DECISION DELEGATED TO HEAD OF PLANNING

Application No: H16-0086-23 **Applicant:** Mr Dogan

Proposal: Single storey side extension with relocation of the stair case and first floor rear extension for storage

Location: Mini Poli 20 Winsover Road Spalding

Project	20 Winsover Rd, Spalding PE11 1EJ		
Drawing	Ground floor proposed plan	Scale	1:100 @ A3
No	22_62-P-02	Date	24.10.2022
Rev No	V2	By	U. Turk

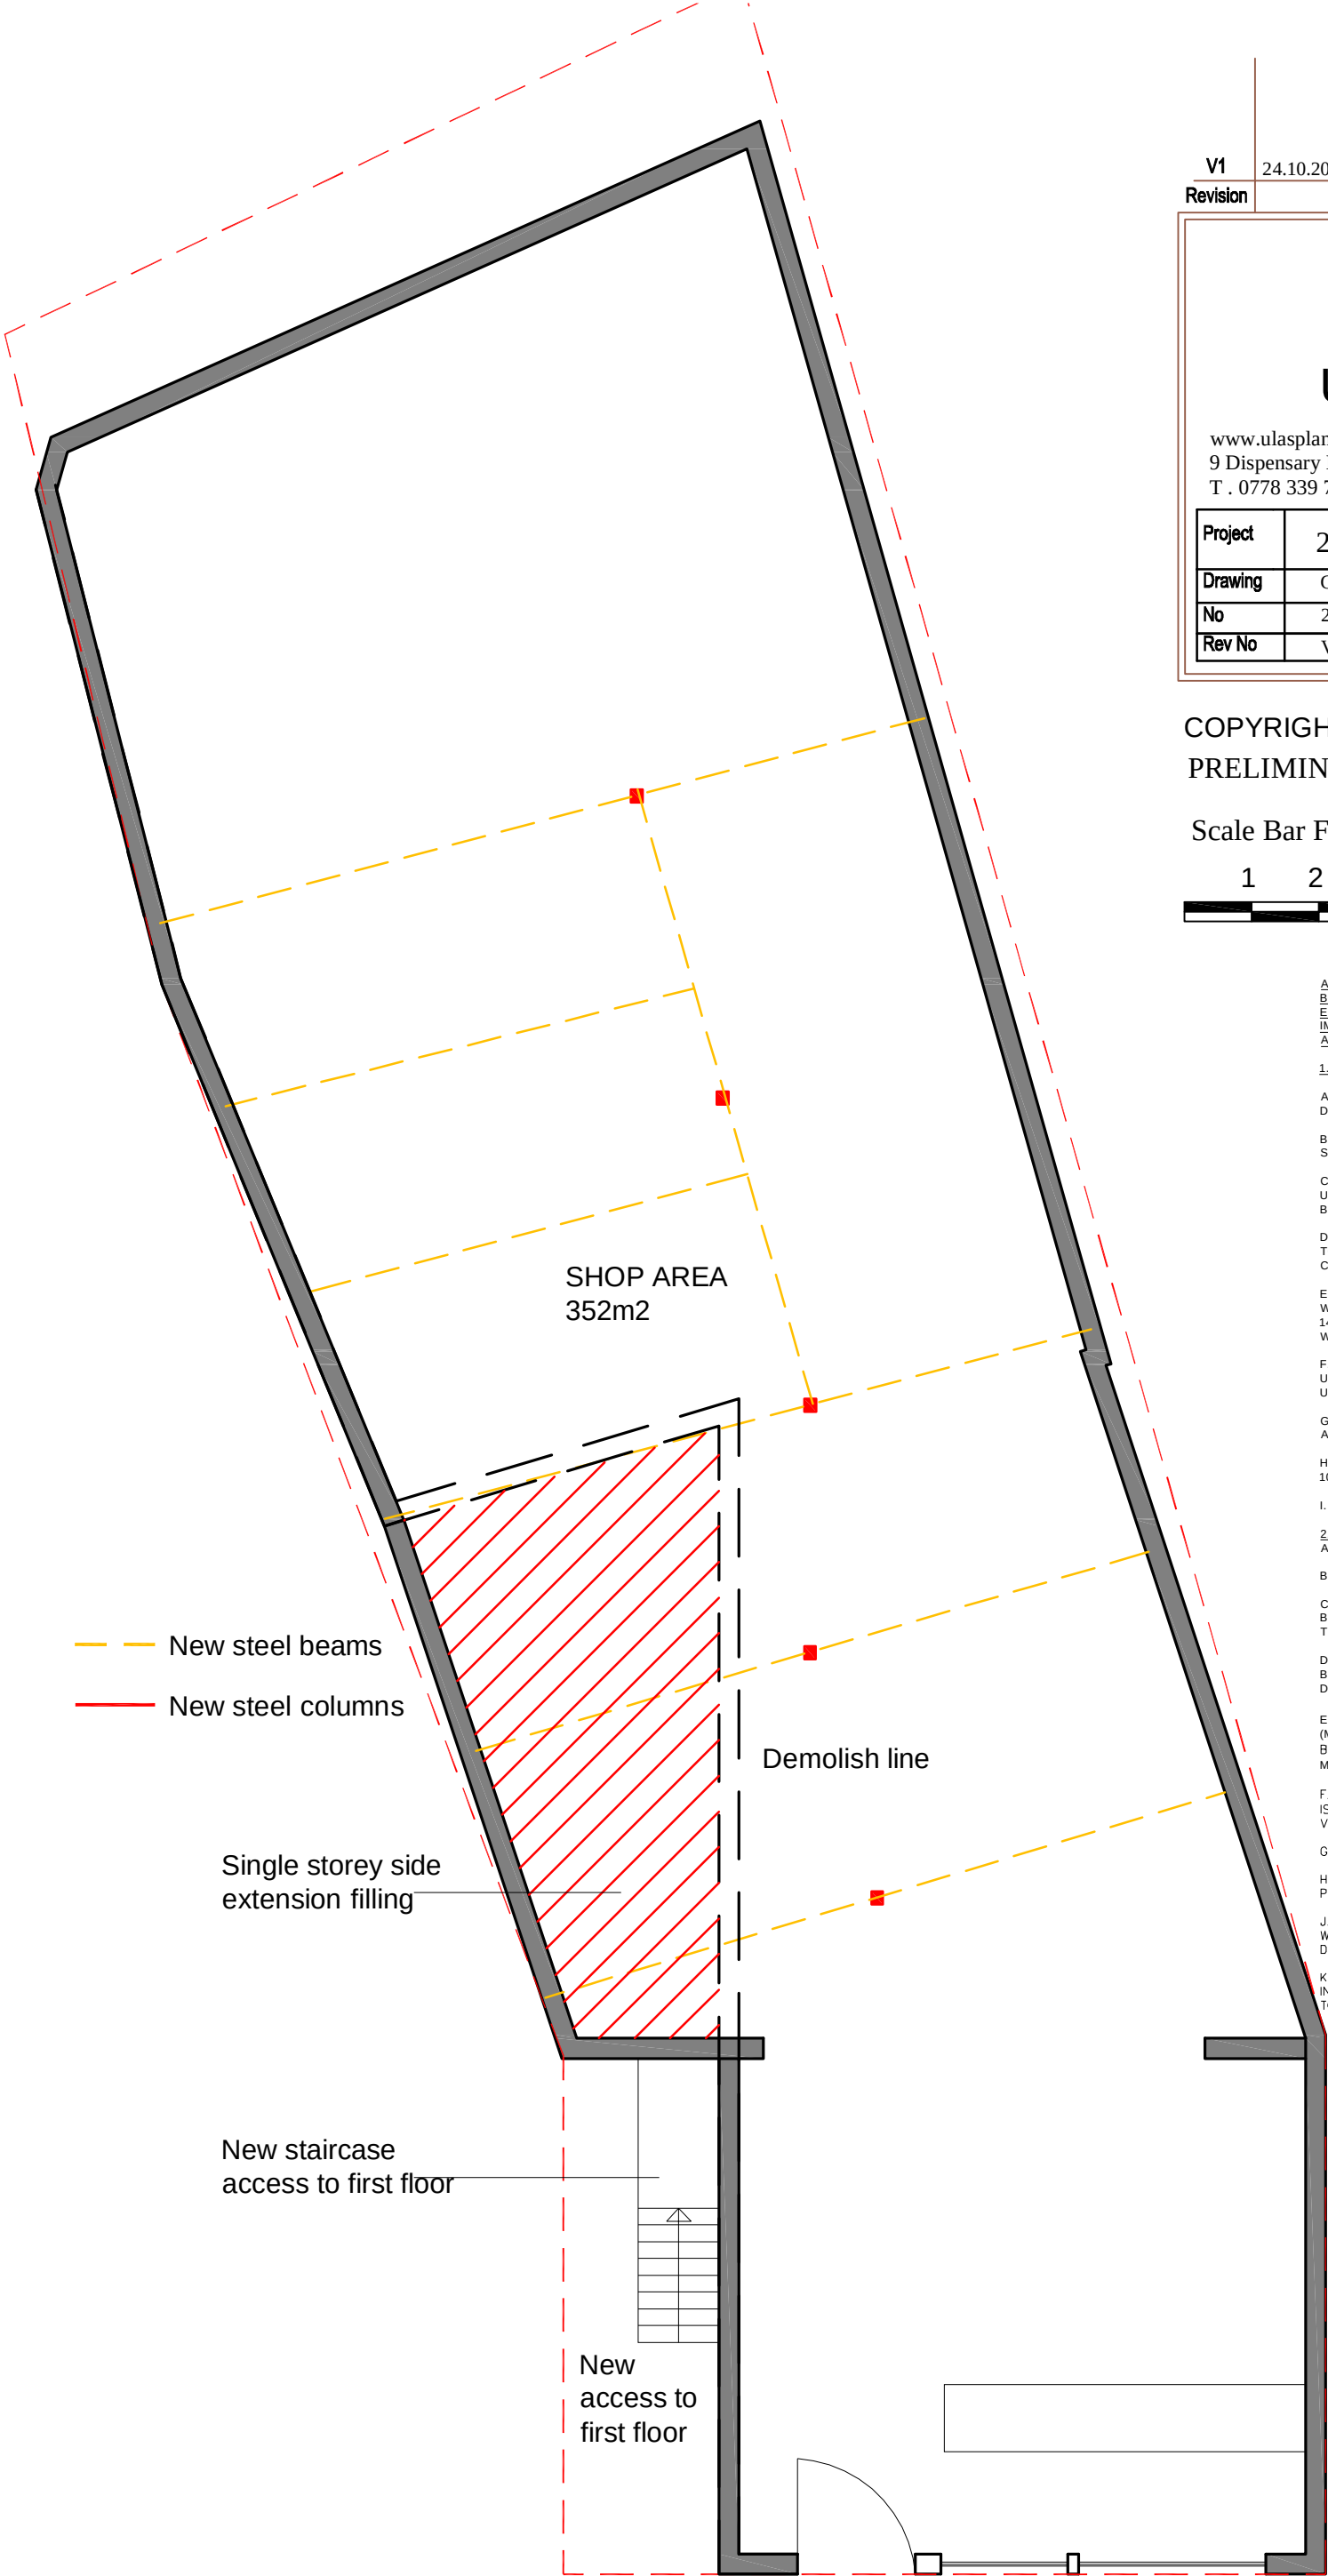
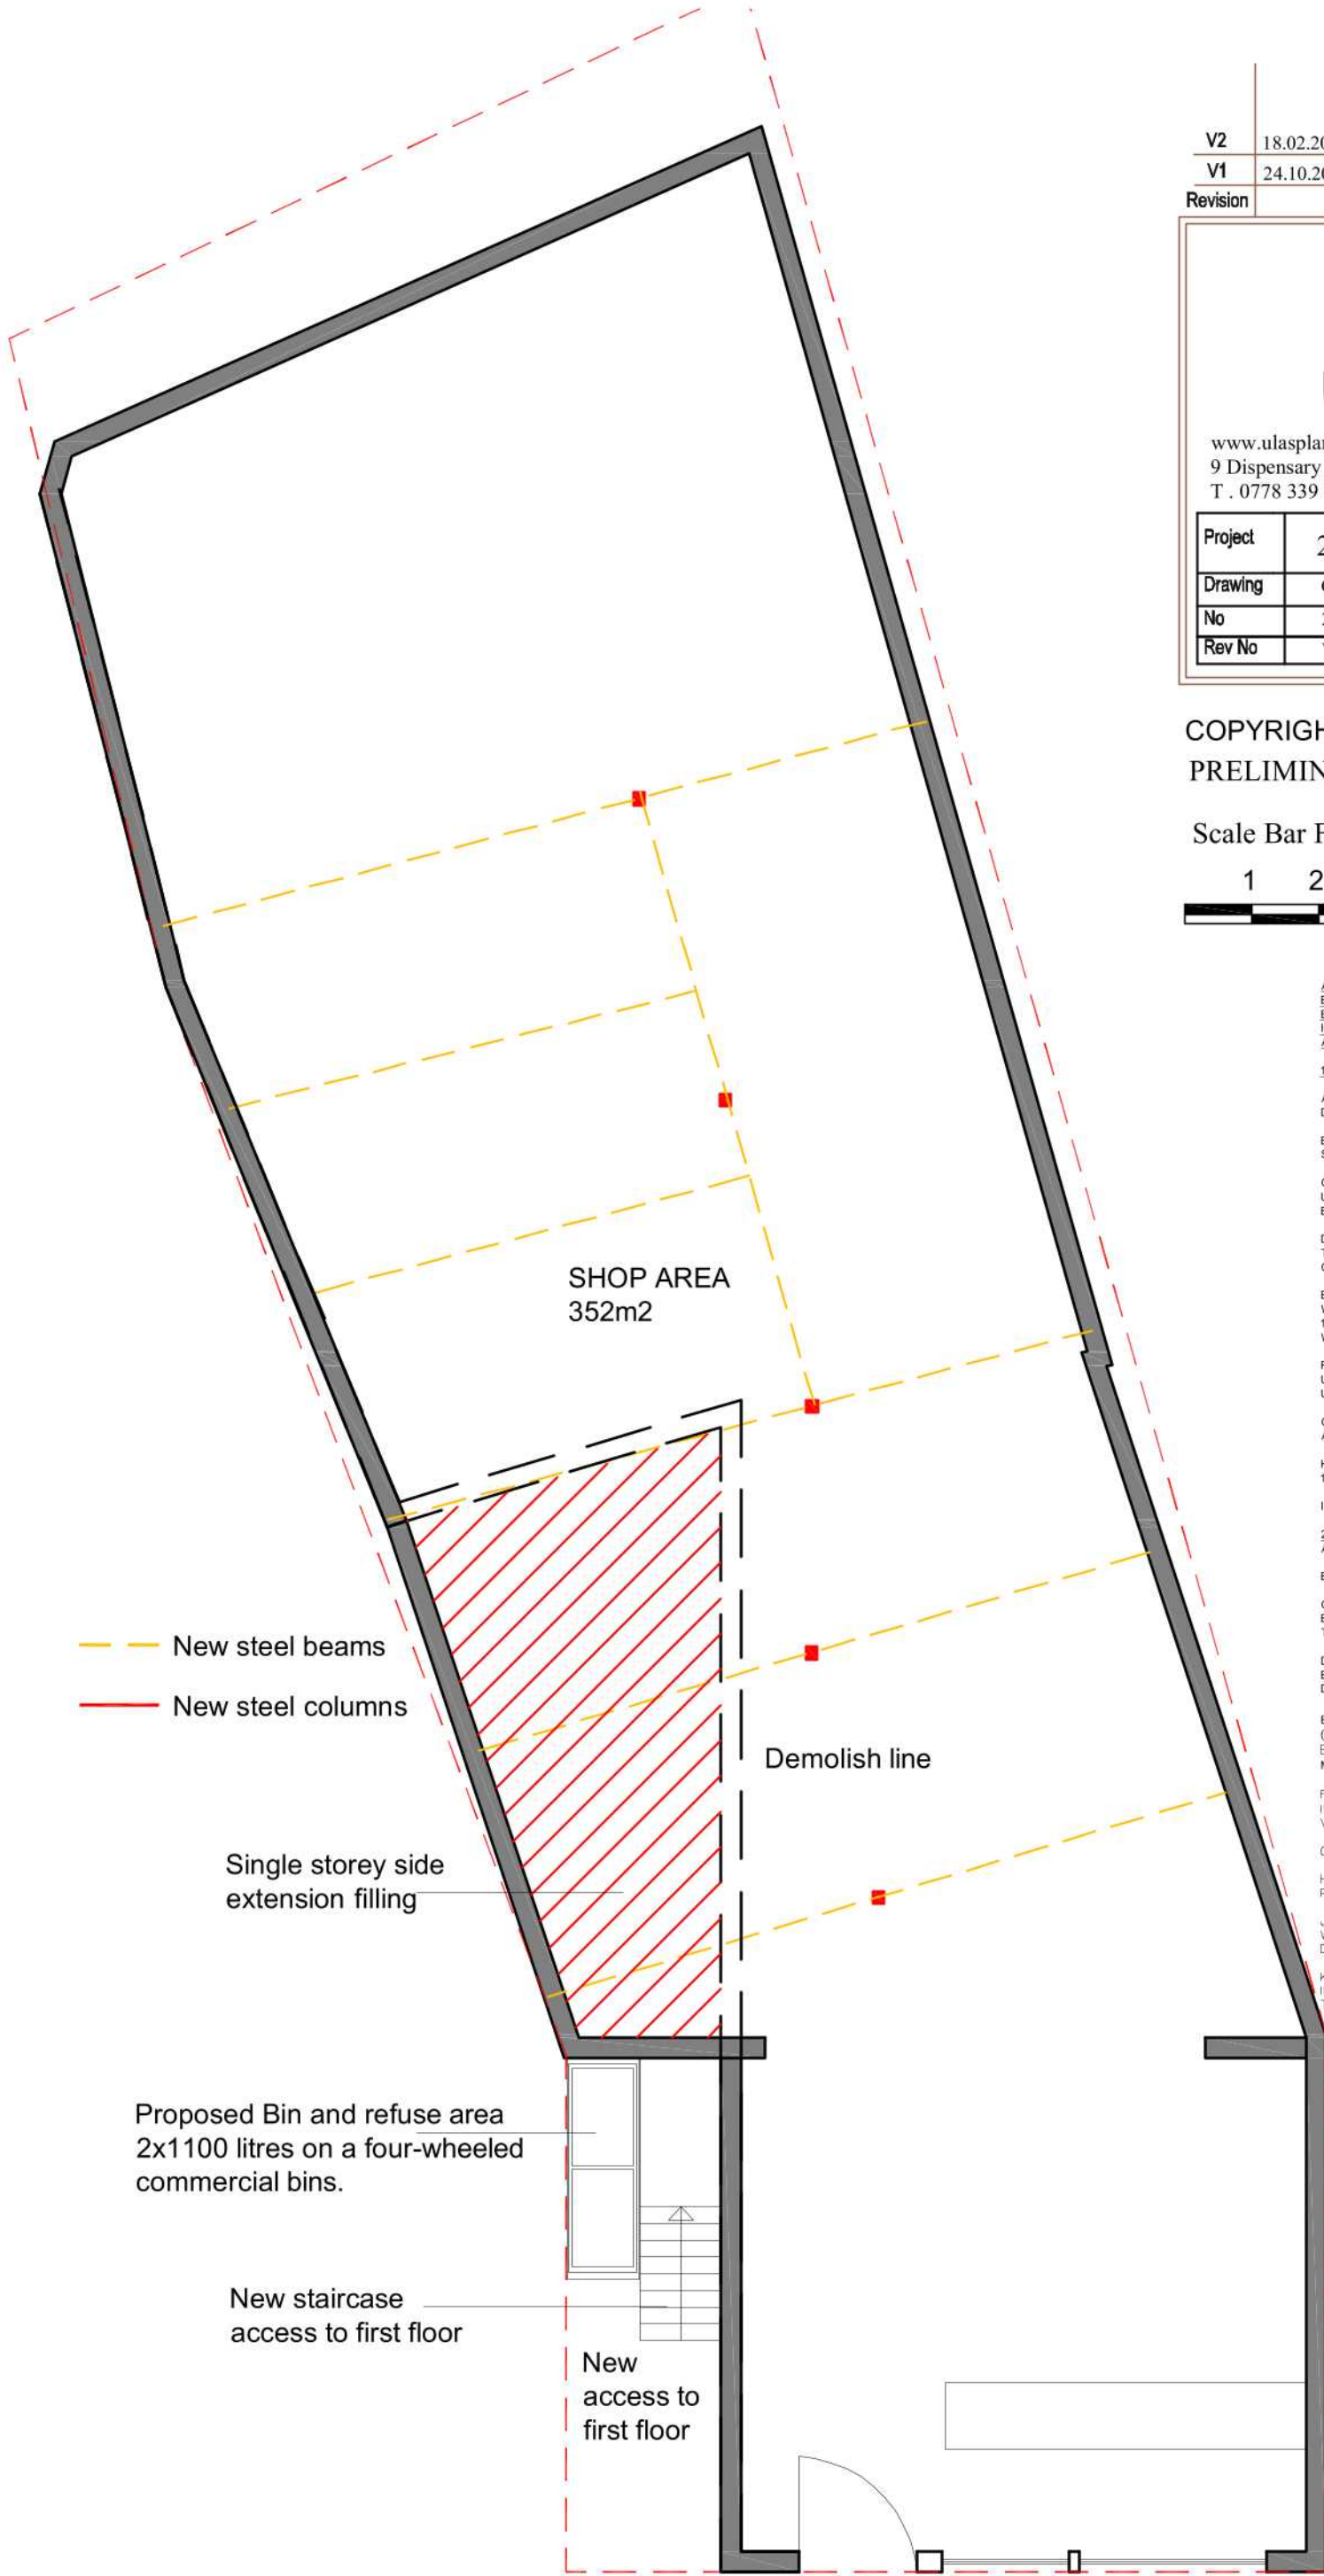
Amended plans show that refuse would be stored in two large, commercial bins adjacent to the proposed staircase. This is considered acceptable and will prevent the storage of refuse spilling out onto the adjacent street.

The proposed refuse disposal and storage arrangement is considered acceptable.
